CITY OF ALBUQUERQUE

January 3, 2025

Re: GS Dental office
7030 Holley Ave. NE
30-Day Temporary Certificate of Occupancy
Transportation Development Final Inspection
Architect's Stamp dated 06-09-23 (C19-D046)
Certification dated 12-19-24

12 | bike rack detail
A001 1/2"=1'-0"

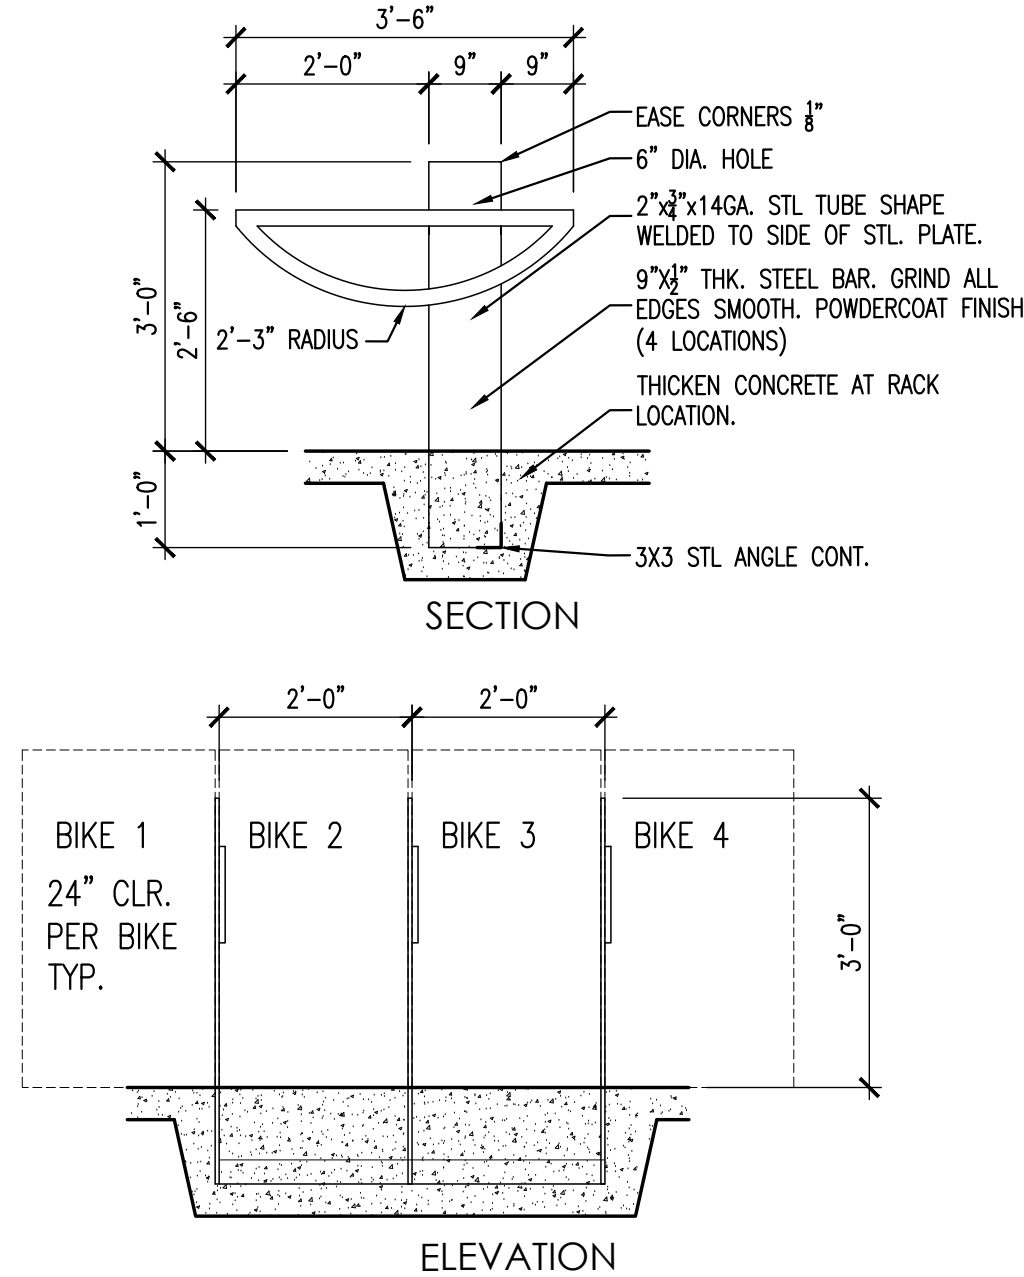
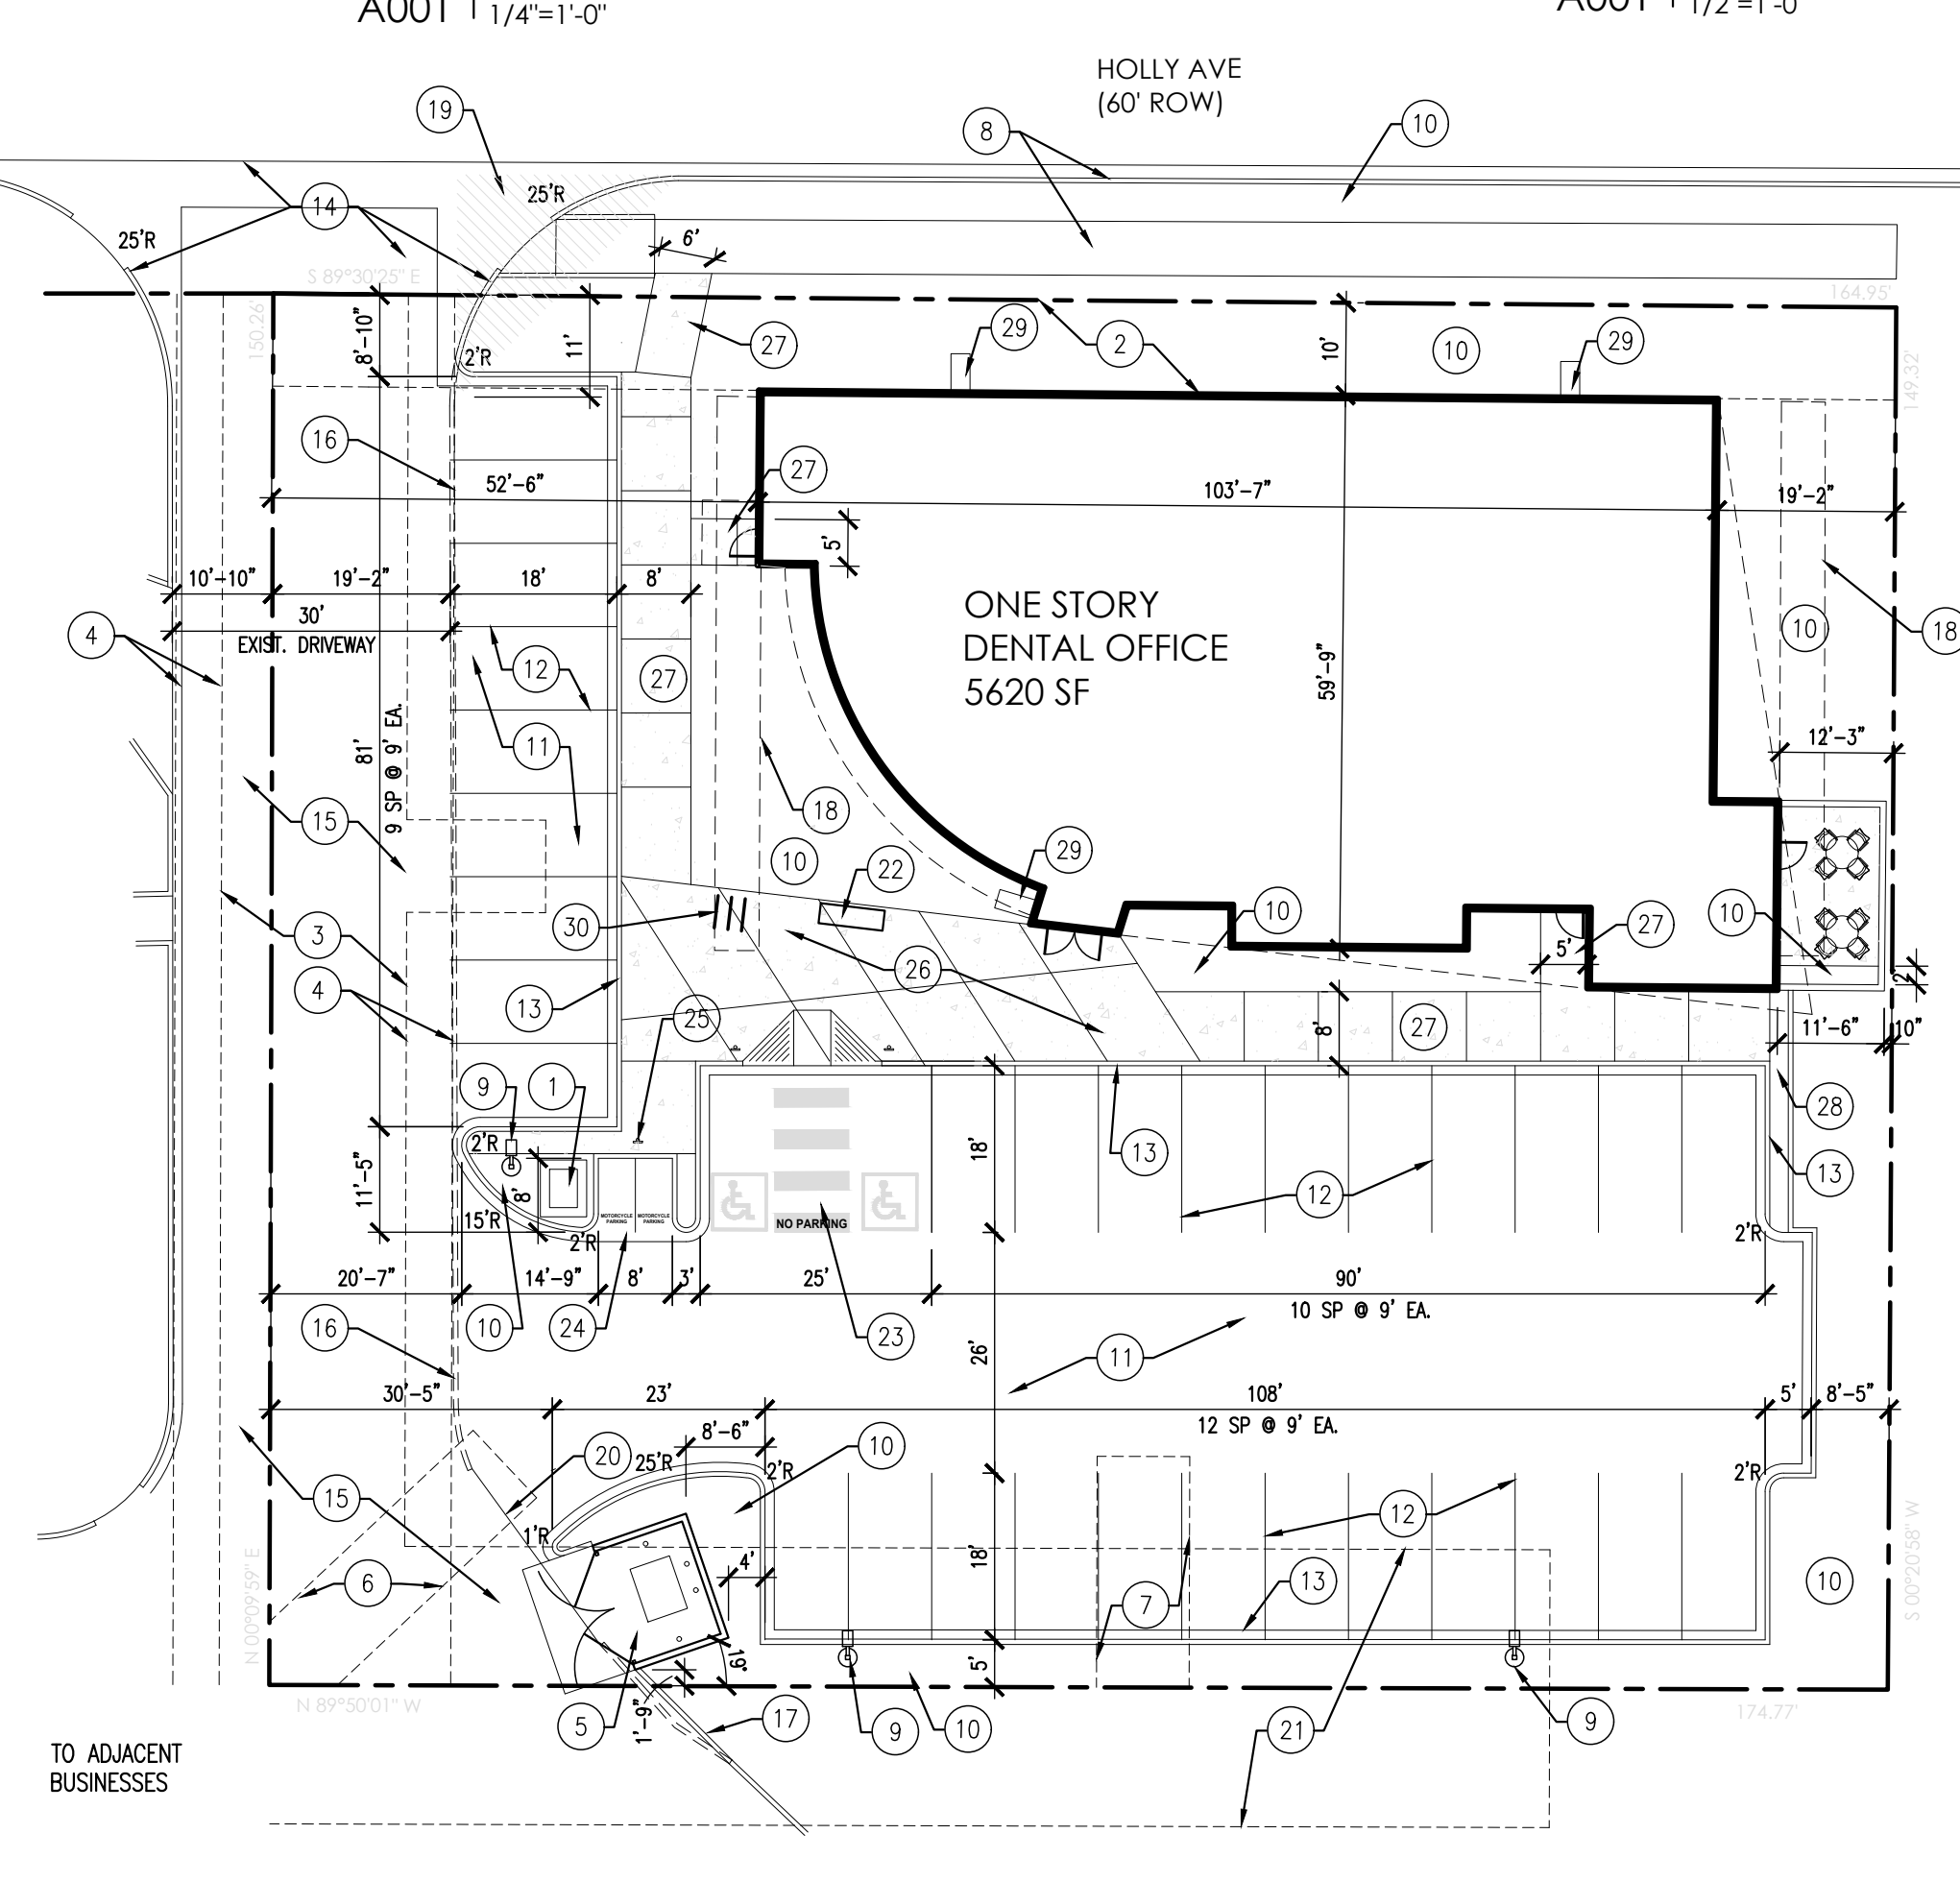
- Anchor down Bike Rack.
- Keynote 14: Truncated Domes must be installed at ADA ramp within the city right of way.
- Construction must be completed. Too much construction activity happening on the site.
